**RE: Transmittal of Comments – Monahan Mountain Tree Farm Tracts Large Lot (LL-08-05)  
Monahan Mountain Forest Tracts Large Lot (LL-08-04)**

TO: Trudie Pettit, Community Development Services  
FROM: Randy Carbary, Planner II *rc*  
DATE: May 30, 2008  
SUBJECT: Monahan Mountain Forest Tracts Large Lot Subdivision LL-08-04

TO: Trudie Pettit, Community Development Services  
FROM: Randy Carbary, Planner II *RC*  
DATE: May 30, 2008  
SUBJECT: Monahan Mountain Tree Farm Tracts Large Lot Subdivision LL-08-05

Kittitas Co. Large Lot Subdivision NO. 08-XX		
Portion of Section 14, Twp. 20N., Rge. 13E., W.M.		
Kittitas County, Washington		
DWN BY G. WEISER	DATE 04/08	JOB NO. 05502-4
CHKD BY D. NELSON	SCALE 1"=300'	SHEET 1 OF 2

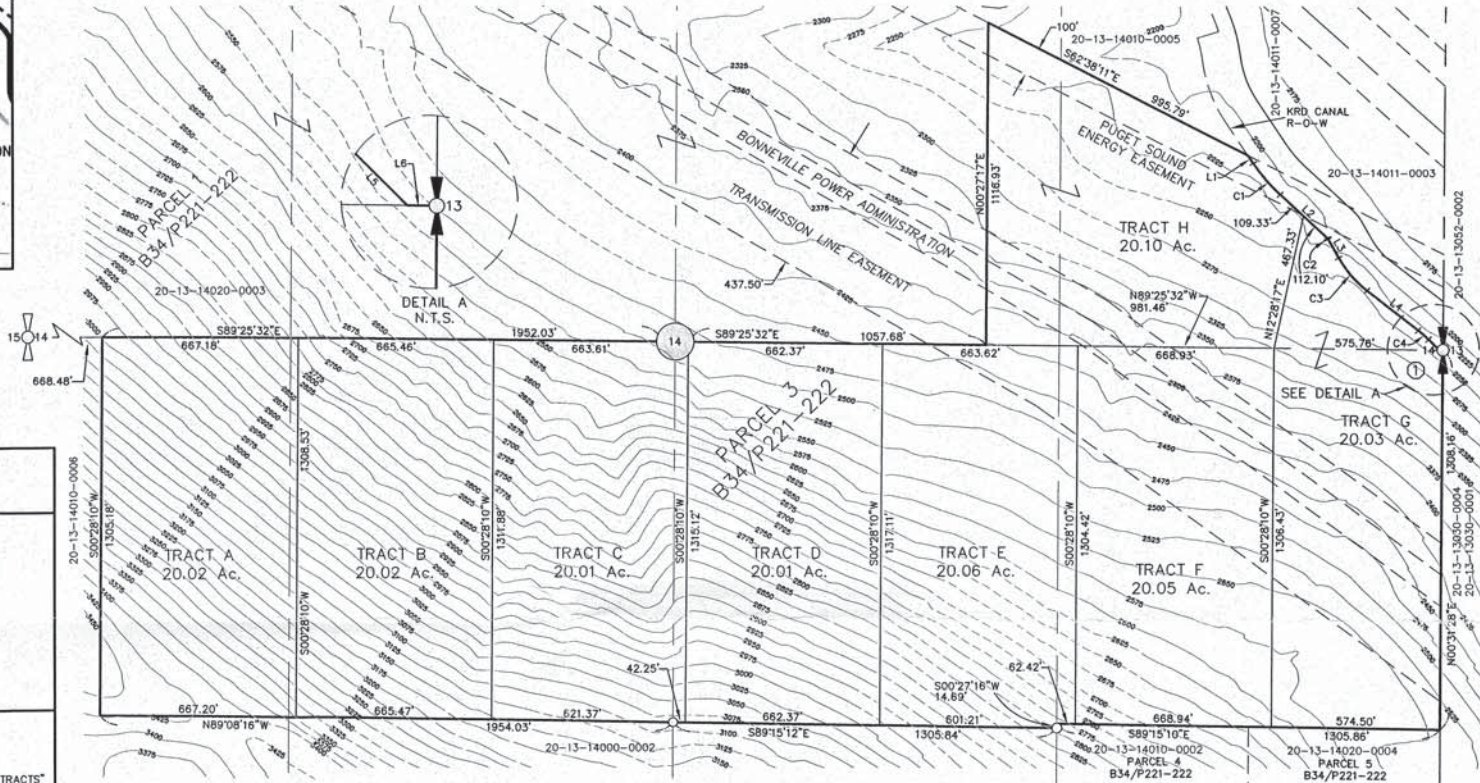
1. Access: The proposed Large Lot Subdivision does not appear to depict any access easement on their application. In order to review the application, the access to all lots shall be clearly depicted on the face of the plat.
